Application number: 2021/94599	
What is the application for?:	Erection of 6 dwellings and associated works
Address of the site or building:	Moorhouse Farm, Moorhouse Lane, Birkenshaw, BD11 2AY
Postcode:	BD11 2AY

# Proposed Site Layout - 1:750

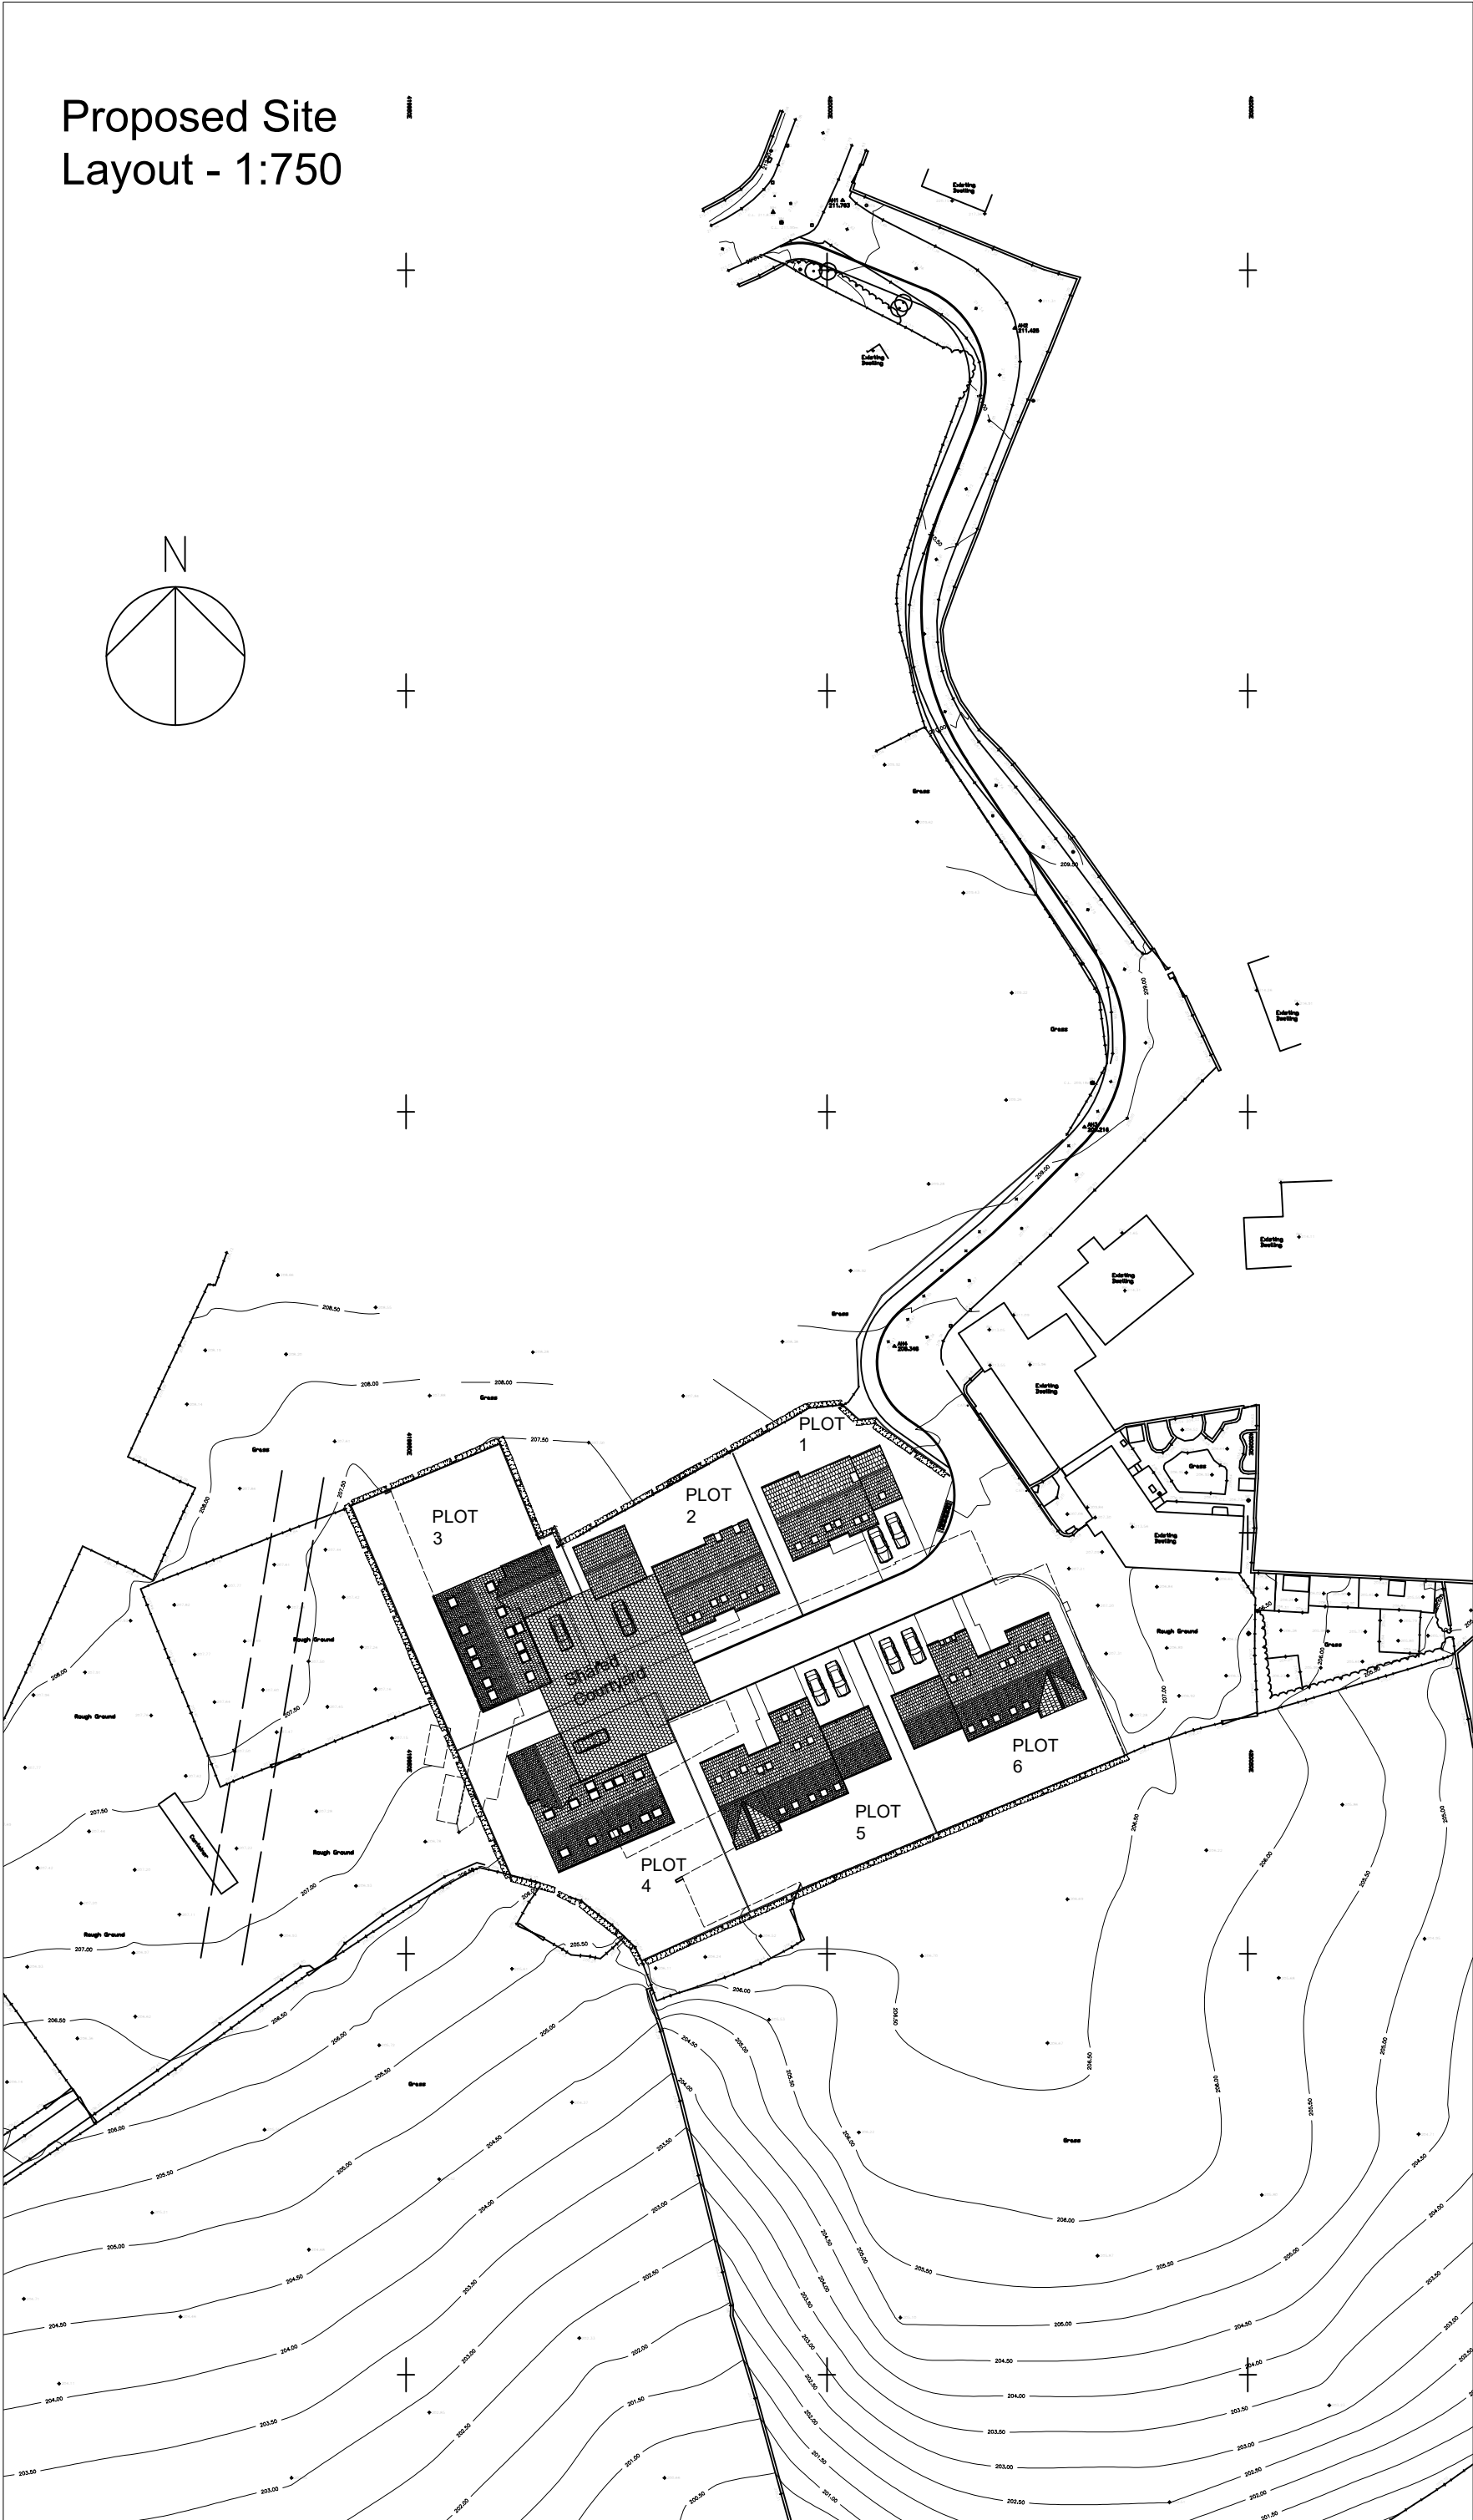
Type of comment: A general comment	
Do you wish your comments to be published on the website anonymously?	Yes
<p>The plans do not accurately explain where the boundaries of the proposed new road will be positioned in relation to the existing houses on Moorhouse Lane. Vehicles currently park on Moorhouse Lane outside existing houses and the plans need to clearly state whether this would be affected by the new access road. If the new road does affect this current parking it would not achieve its objective as one lane of the road would be constantly blocked by parked vehicles belonging to the existing houses.</p> <p>More clarity is also needed around the sewerage provisions for the proposed dwellings. The existing sewers have previously been subject to collapse due to their age and there are concerns as to whether they would be able to cope with 6 more substantial dwellings.</p>
